SECOND CHANGE APPLICATION REPORT

Drax Bioenergy with Carbon Capture and Storage

Document Reference Number: 8.15

Applicant: Drax Power Limited

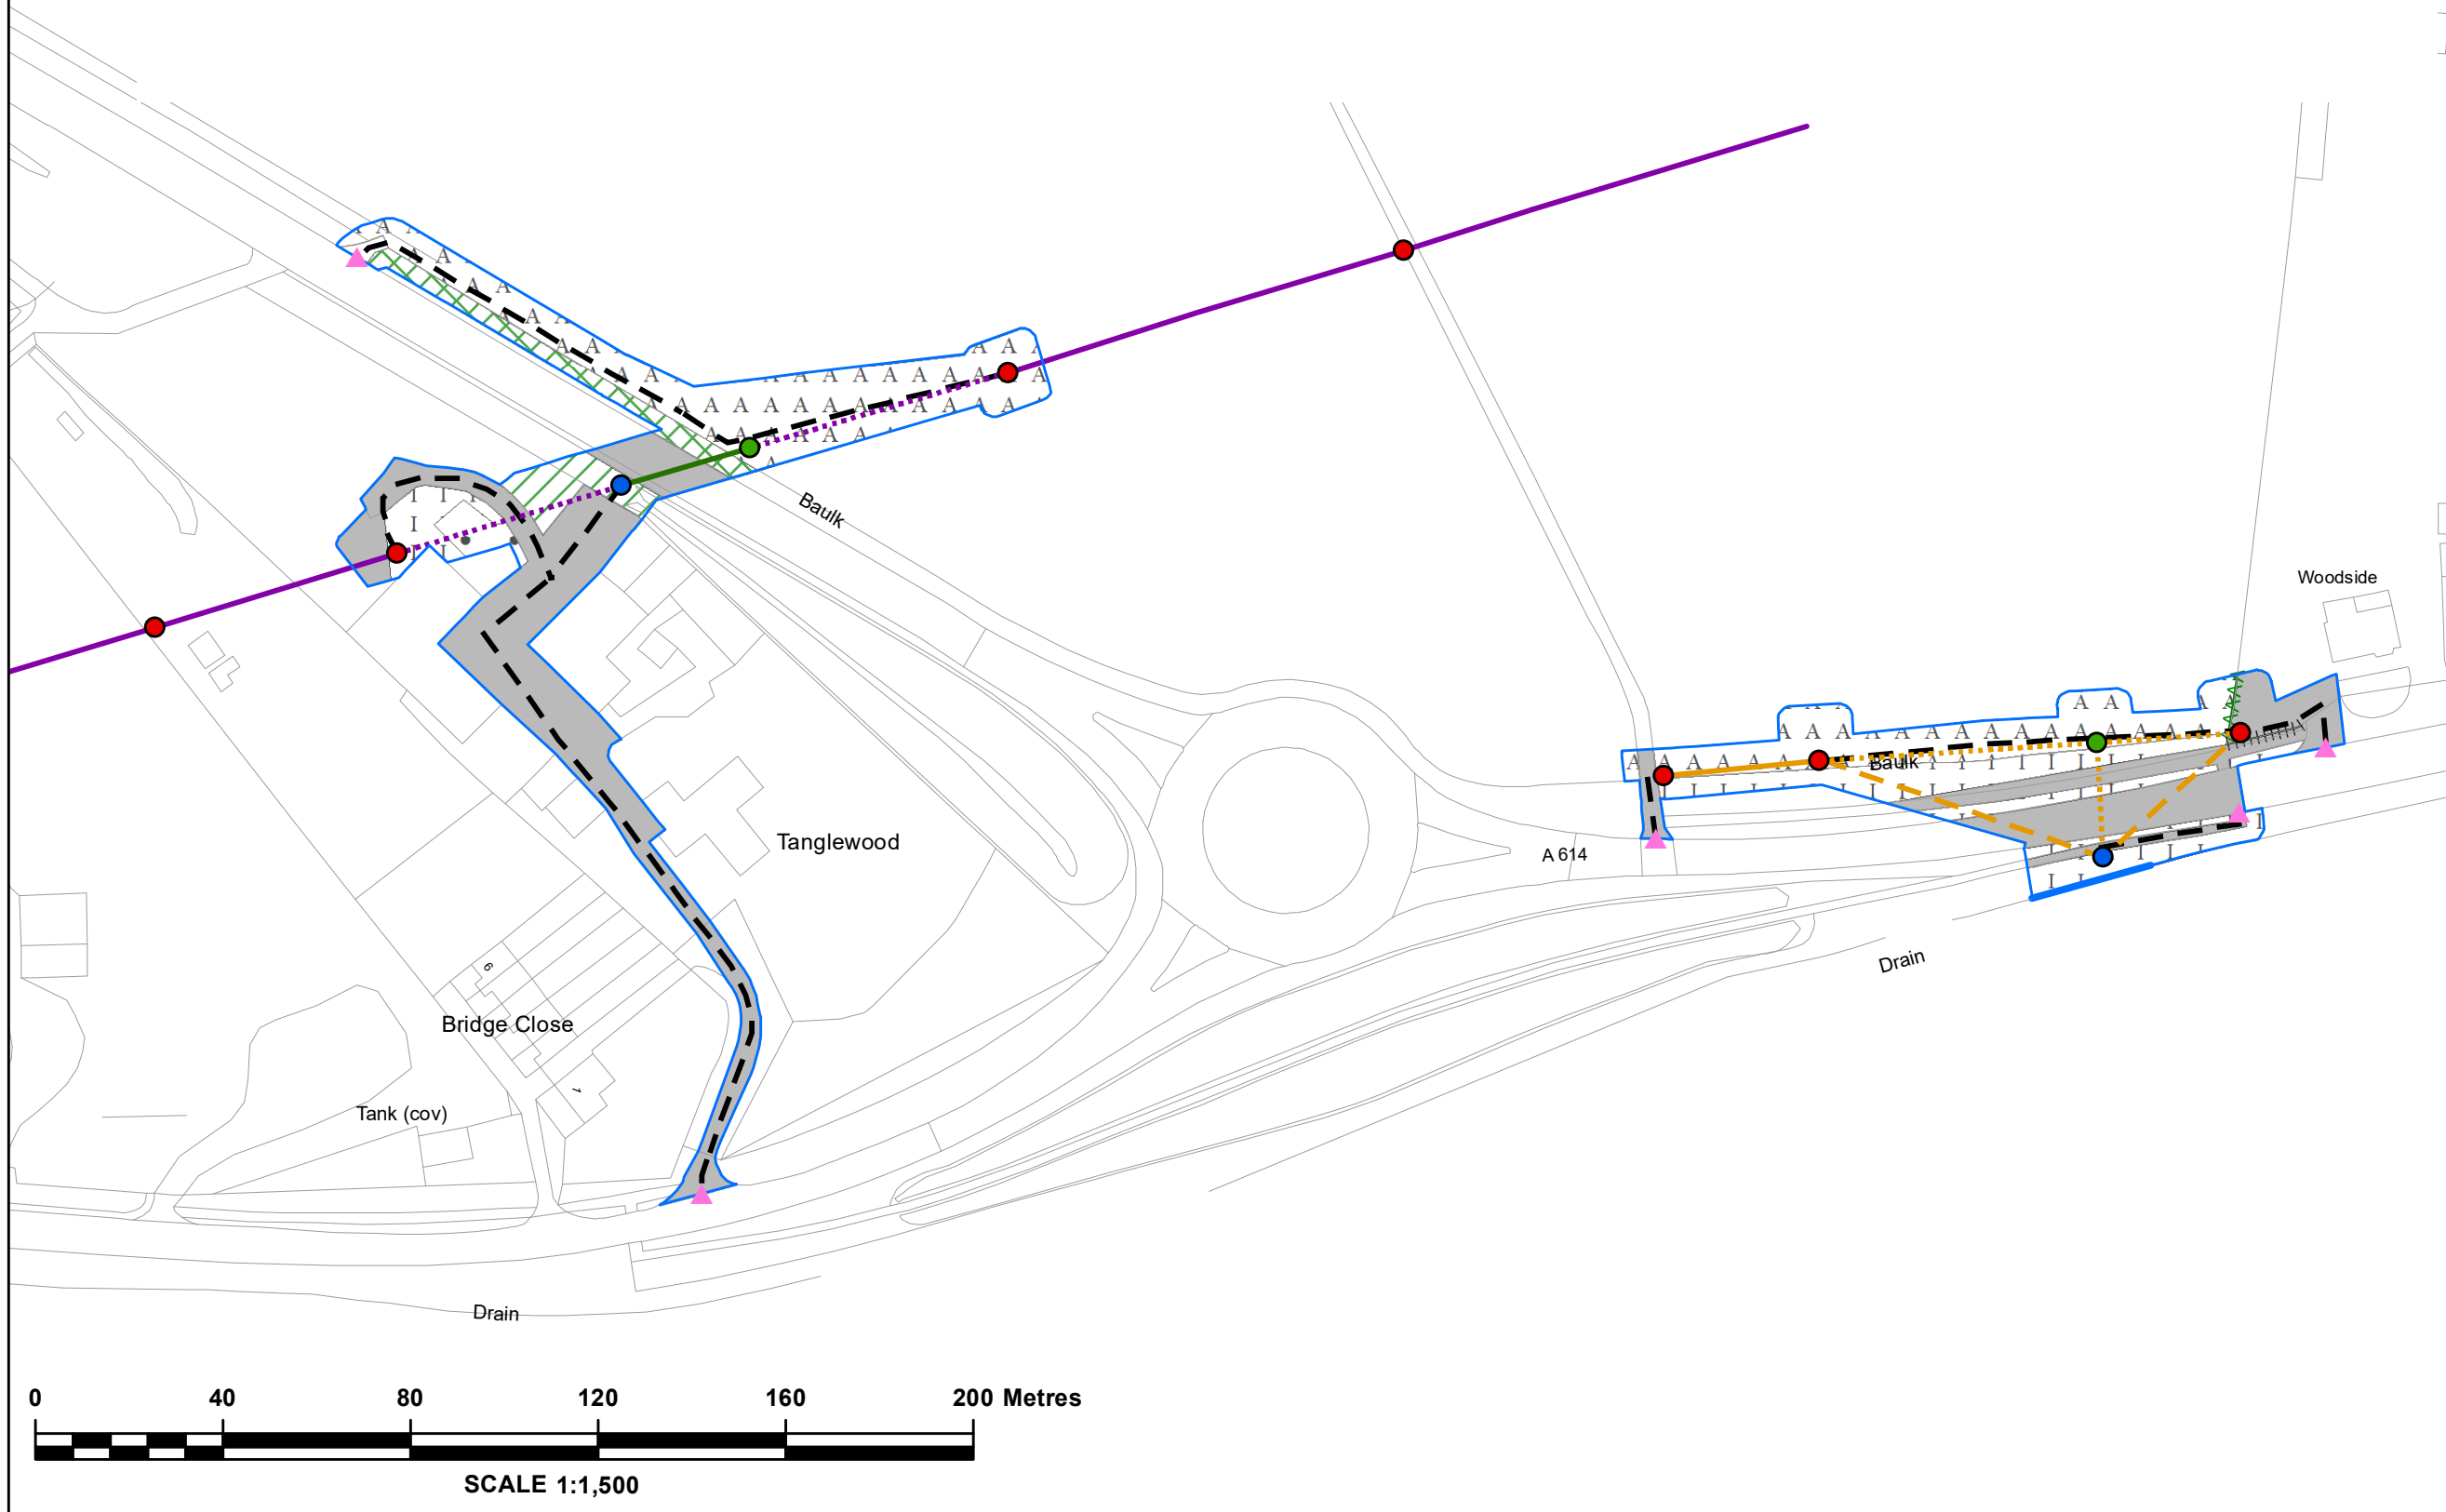
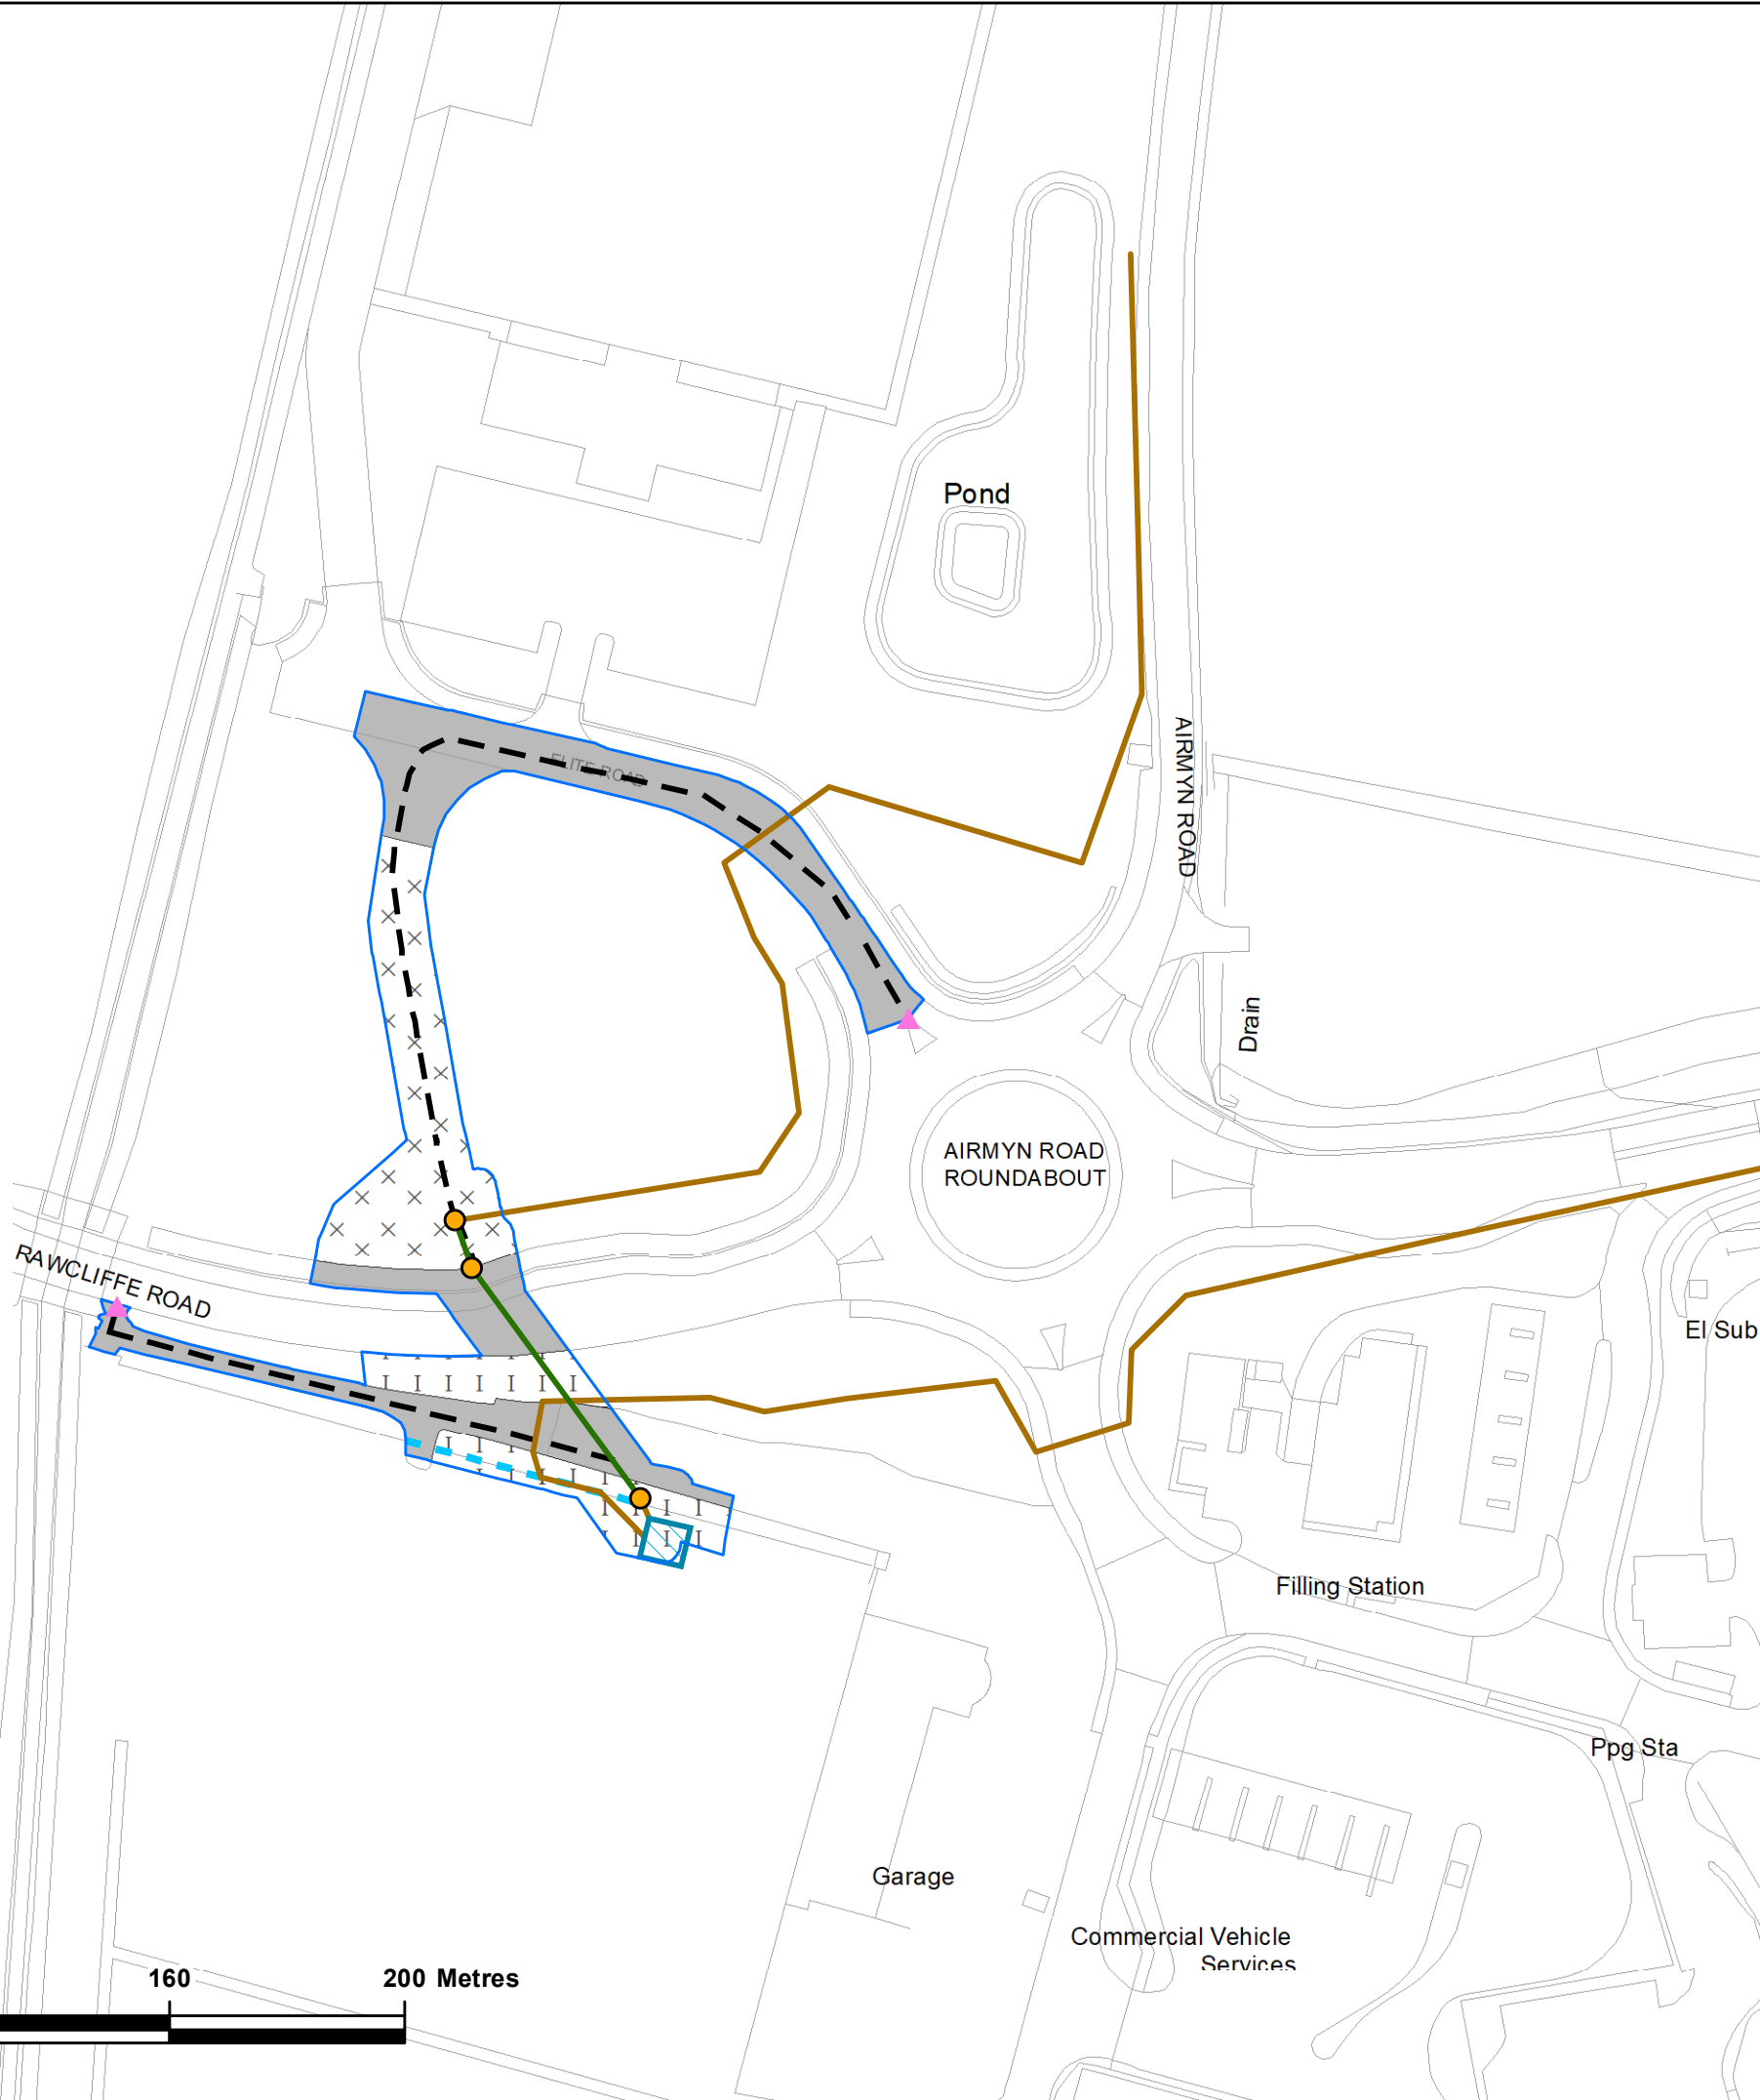
- 2.3.14. The asset owner, Northern Powergrid's preferred design for the works has confirmed that undergrounding via a trenchless installation method such as HDD was not feasible due to other utility assets in the locality, and that the installation of the undergrounded section of the electrical cable would be via an open trench installation method across the Rawcliffe Road to connect to existing underground electrical cables at the northern and southern end of the existing overhead line. The asset owner has confirmed that it would prefer to retain the electrical infrastructure in its current alignment with the undergrounded section being across the highway also following the alignment of the existing overhead line within a 10m wide corridor to provide flexibility to adjust the exact routing to navigate around existing infrastructure in/under the highway and adjoining land.

- 2.3.18. There is no longer a need for land to accommodate potential HDD/works compound on the southern or northern side of the A614 or a requirement to install any new wooden poles or above-ground electrical infrastructure in this location, and therefore these areas of land will be removed from the Order Limits.
